Recommendation Report for Planning Permission for Works or Extension to a Dwelling

REF NO: FG/38/21/HH

LOCATION: Franklands Manor
48 Ferring Lane
Ferring
BN12 6QT

PROPOSAL: Erection of garage following demolition of existing.

Proposed Elevations

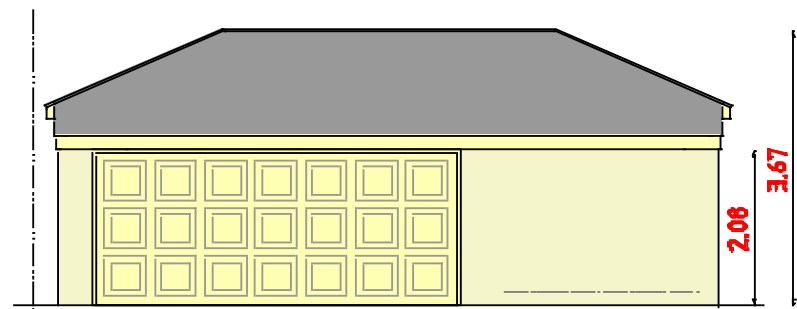
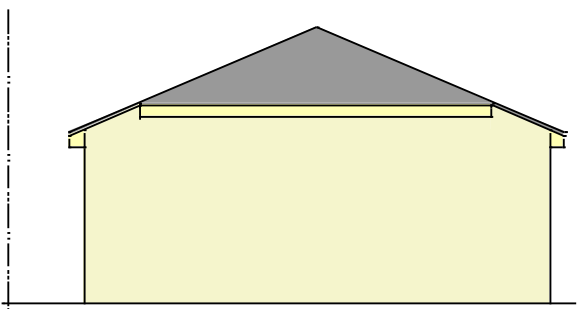
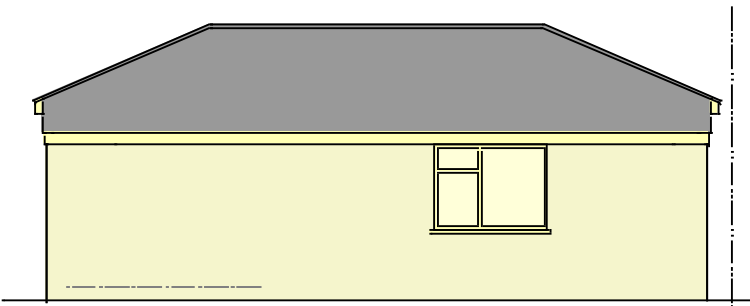
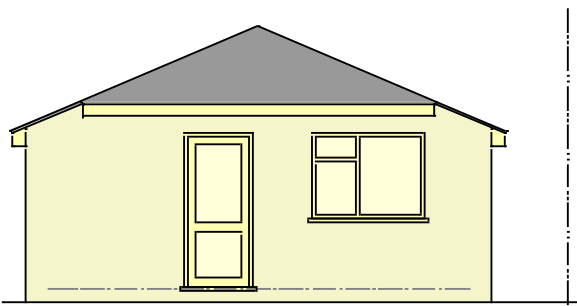
DESCRIPTION OF APPLICATION The proposal seeks to demolish a row of 3 attached flat roofed garages and replace them with a hipped shallow pitched roofed double garage and attached utility room. The garages would measure 8.8m by 6.2m and would have an eaves height of 2.08m and a ridge height of 3.67m.

The character of the locality is mixed, as a result of the variety of dwelling styles, siting and scales along Ferring Lane. The garages are in the side garden of the dwelling and the proposal will replace a row of 3 garages. The existing garages are flat roofed and this proposal will replace the structure with a shallow pitched roof building of similar design. Materials are detailed to match existing which are painted render, but the roof material would be altered and is conditioned.

The development is not considered to result in any unacceptable harmful overbearing or overshadowing impact upon the occupiers of nearby dwellings. This is as a result of the siting of the single storey garages being located in virtually the same position as the flat roofed garages and being only slightly higher (1.3m) with the roof pitching away from the boundary, but the relationship with this property is unchanged. The closest neighbouring dwelling to the North is a bungalow and the garages are located

Reason: For the avoidance of doubt and in the interests of amenity and the environment in accordance with policy D DM1 of the Arun Local Plan.
- 3 No development above damp proof course (DPC) level shall take place unless and until a schedule of materials and finishes to be used for the roof of the proposed building have been submitted to and approved by the Local Planning Authority and the materials so approved shall be used in the construction of the building.

Proposed Ground Floor

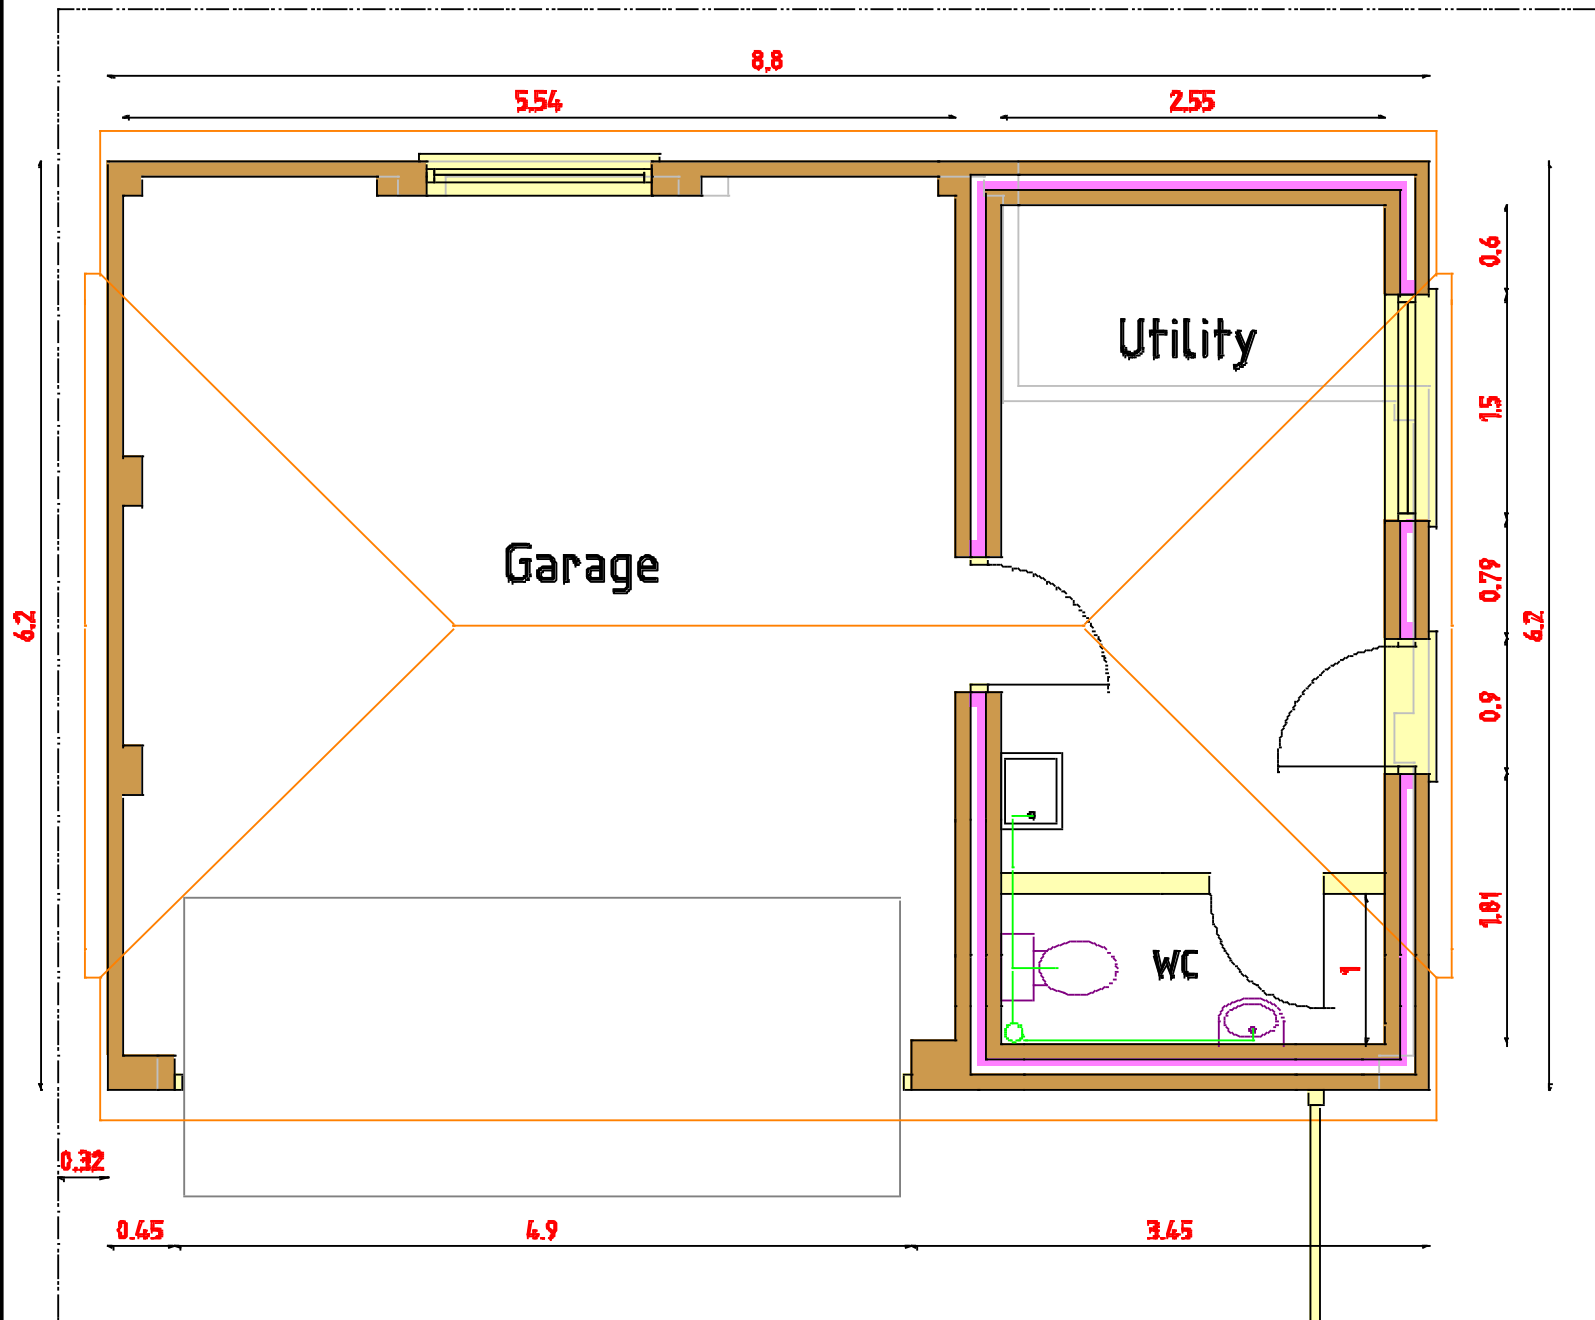
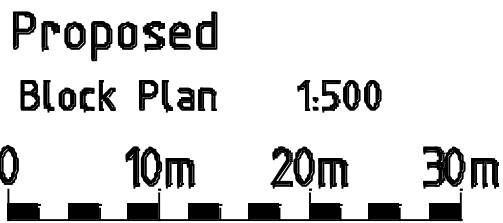
The garage measures circa 5.5m x 6.2m internally which would be insufficient to accommodate 2 vehicles considering Arun's Parking Standard requirements of 6 x 3m for a single garage, therefore only 1 space could be counted counted towards the parking provision. However the internal space is comparable with the existing internal space it replaces. The proposal results in the loss of one garage to a utility room and provides a large double width single garage, but retains 2 parking space in front of the garage. The dwelling that the garage serves would require 2 car parking spaces and this provision is met when the space in front of the garage is included within the parking provision. The proposal therefore accords with policy T SP1 of Arun Local Plan.
